DRB Project Case #: 1008672

Subdivision Name: PERFECTO ARMIJO & BROTHERS ADDITION

DEVELOPMENT REVIEW BOARD – SPEED MEMO

**CITY OF ALBUQUERQUE
PLANNING DEPARTMENT
April 27, 2011
DRB Comments**

**PLAT OF
 LOTS 76-A, 76-B, BLOCK 7
 PERFECTO ARMIJO & BROTHERS ADDITION
 PROJECTED SECTION 17, T. 10 N., R. 3 E., N.M.P.M.
 TOWN OF ALBUQUERQUE GRANT
 CITY OF ALBUQUERQUE
 BERNALILLO COUNTY, NEW MEXICO
 APRIL 2011
 SHEET 2 OF 2**

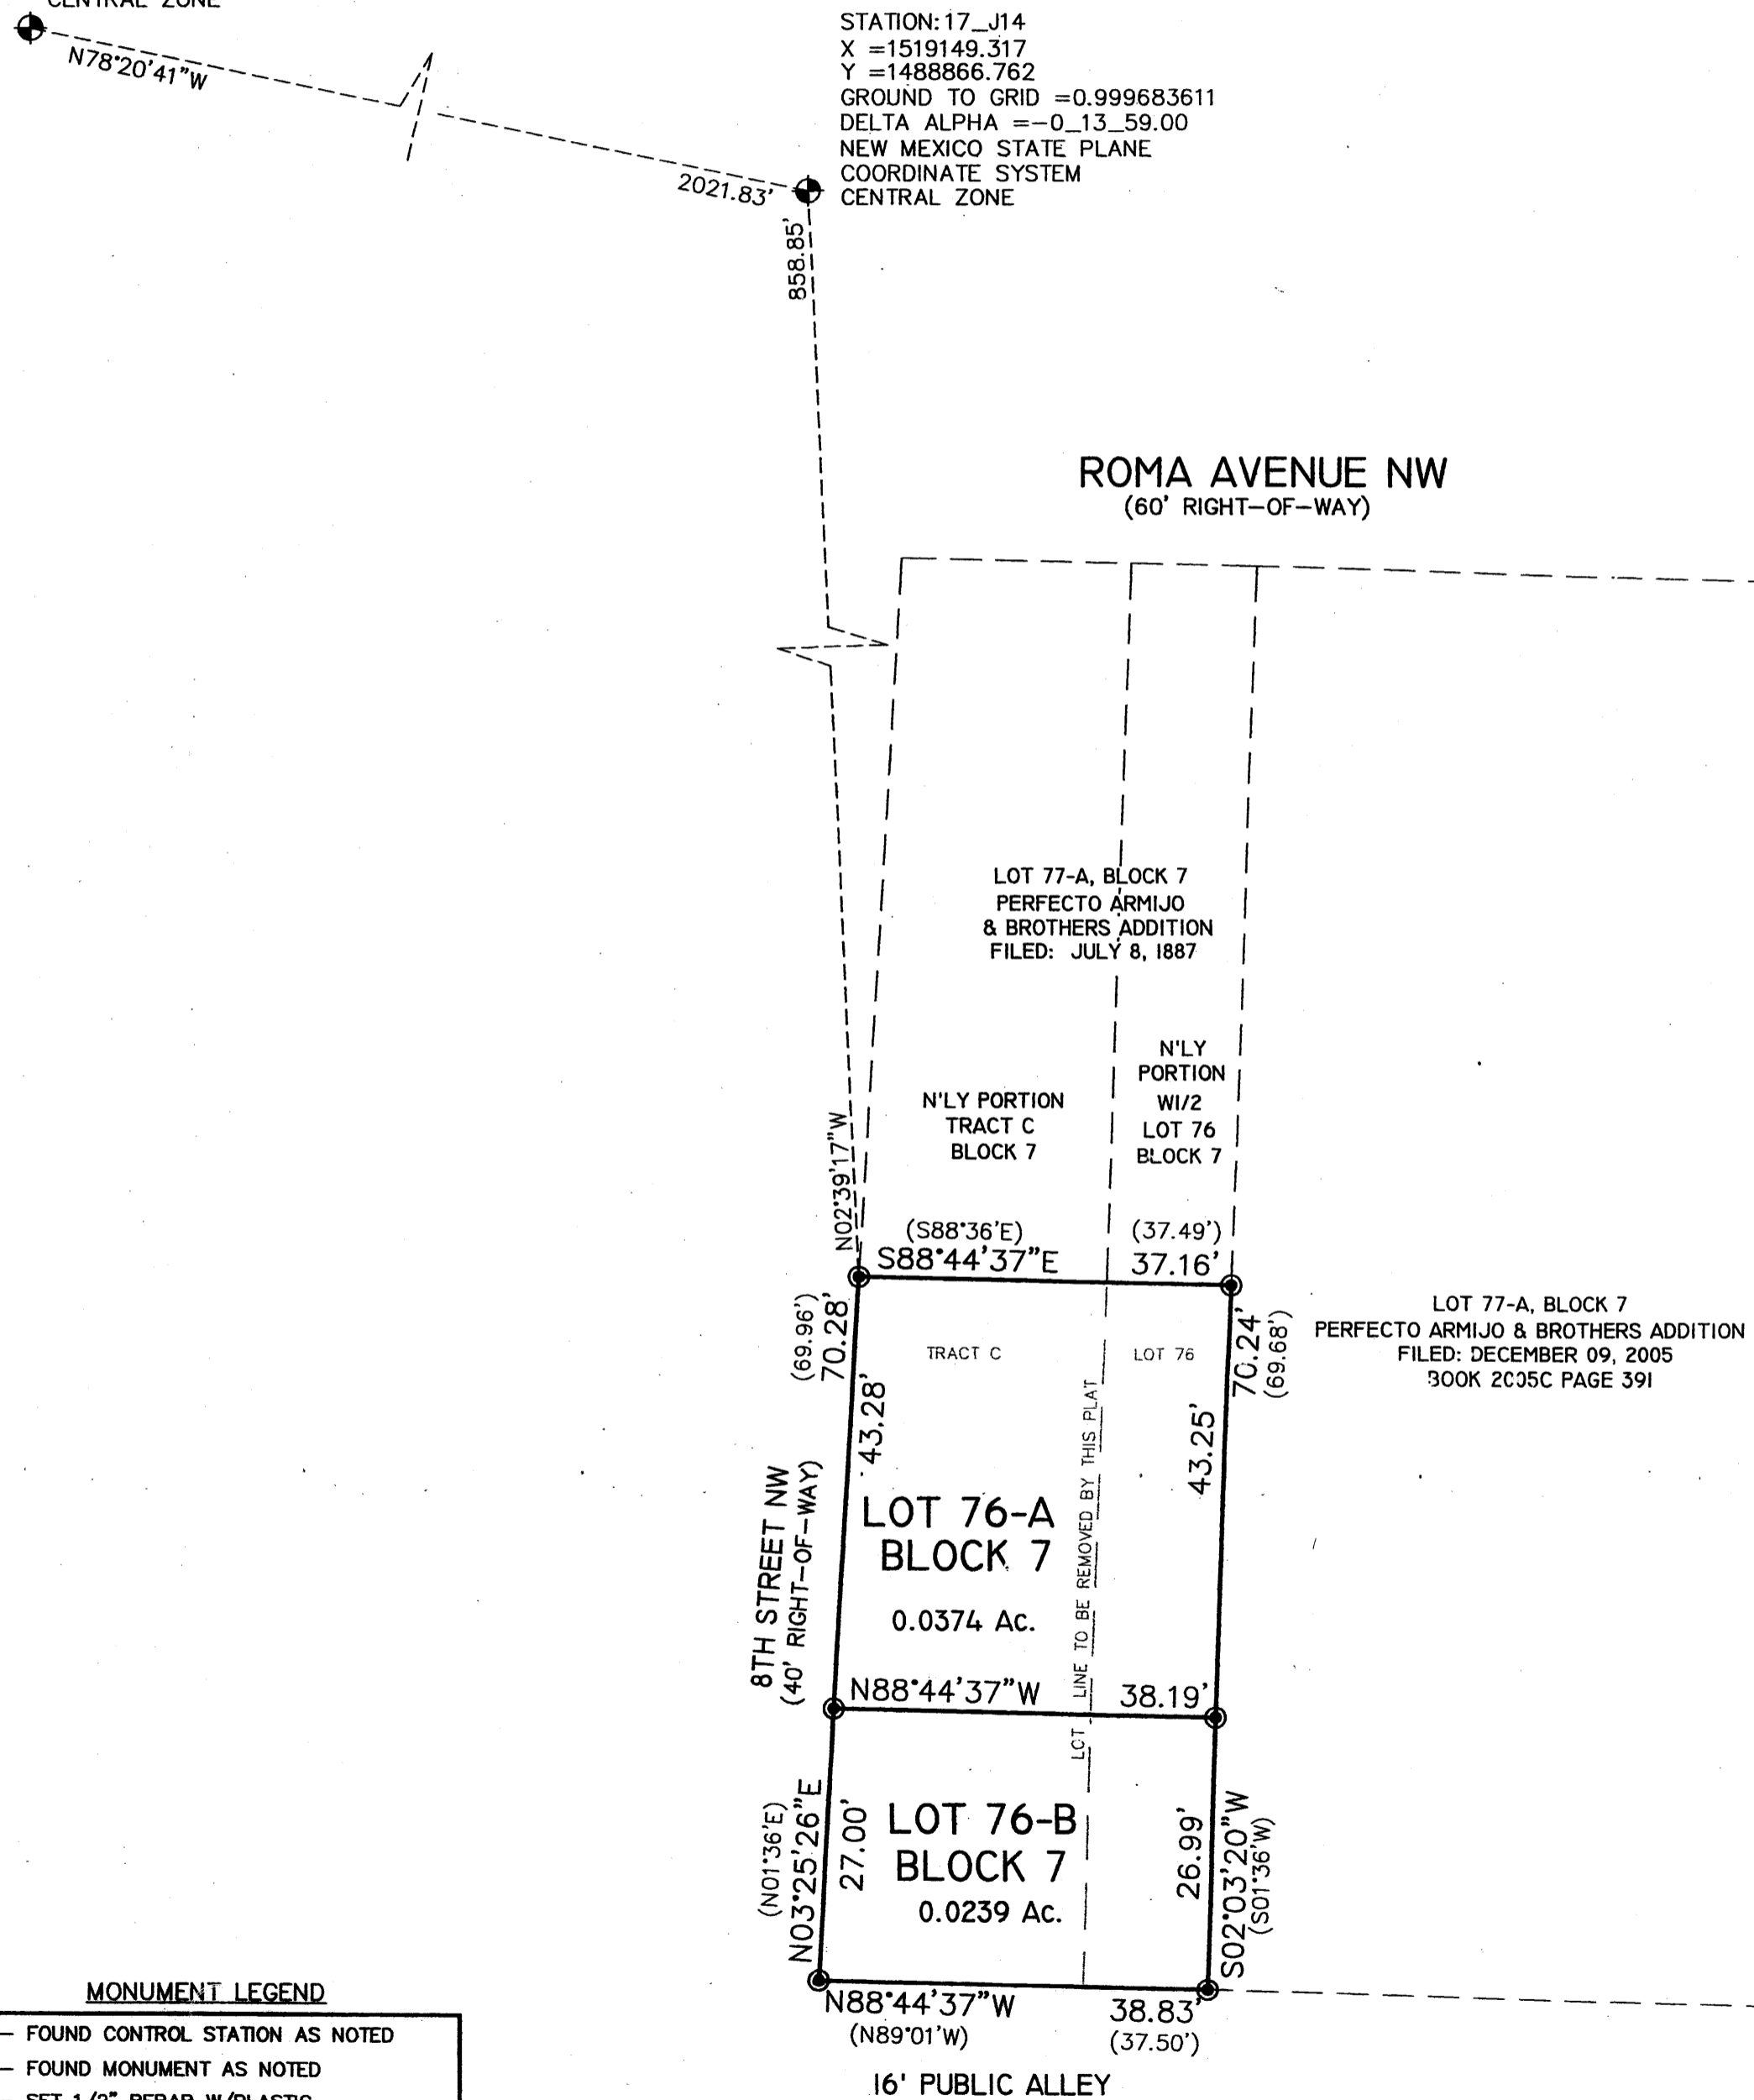
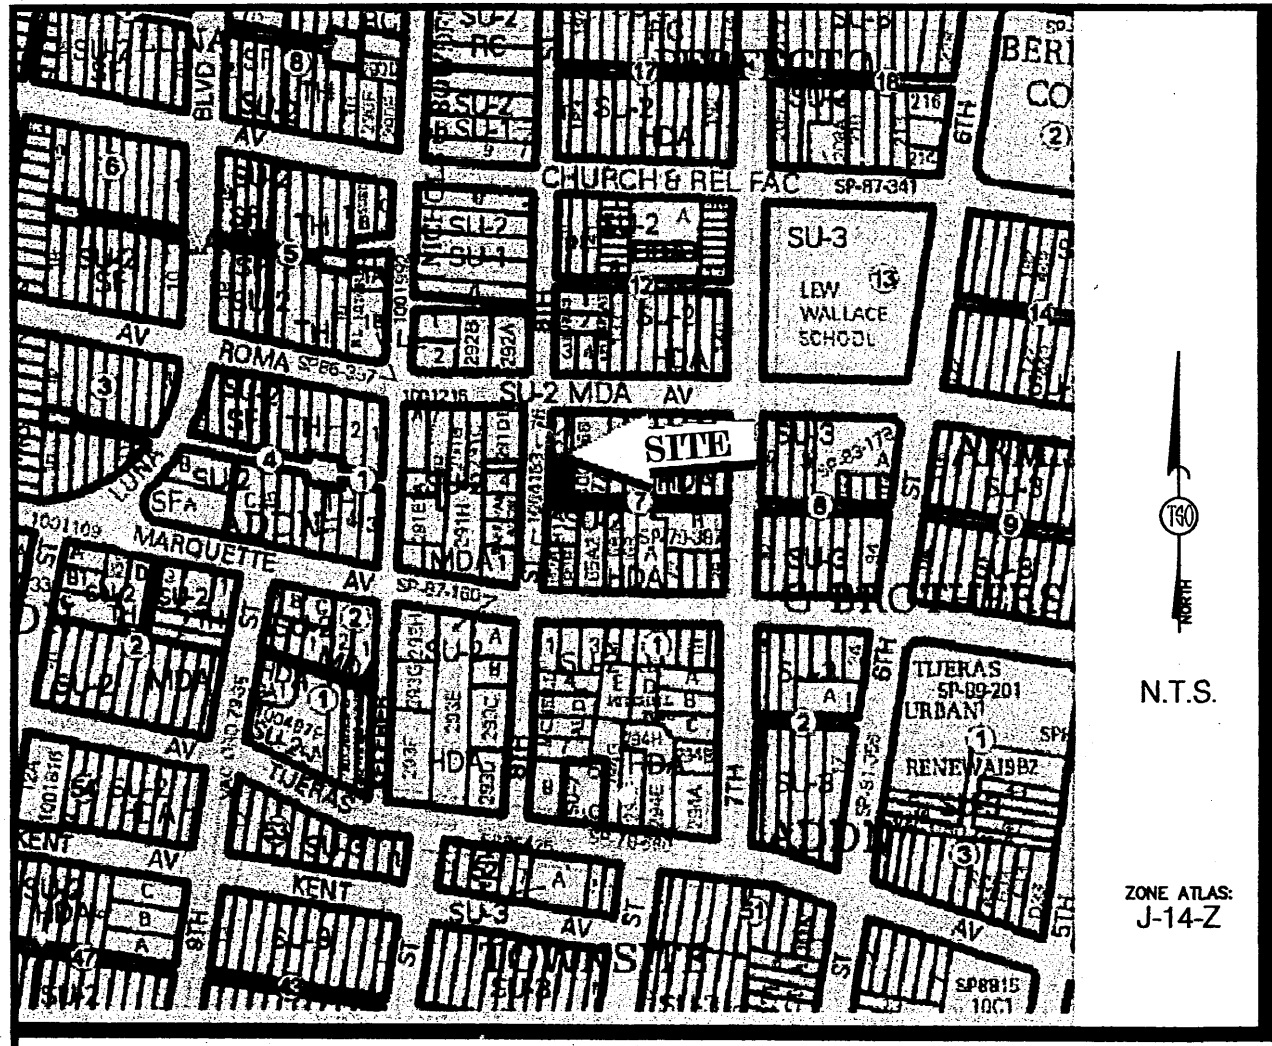
An existing fence is located within the right of way. This fence will require a revocable permit with the City of Albuquerque (contact Jane Rael, 924-3992).
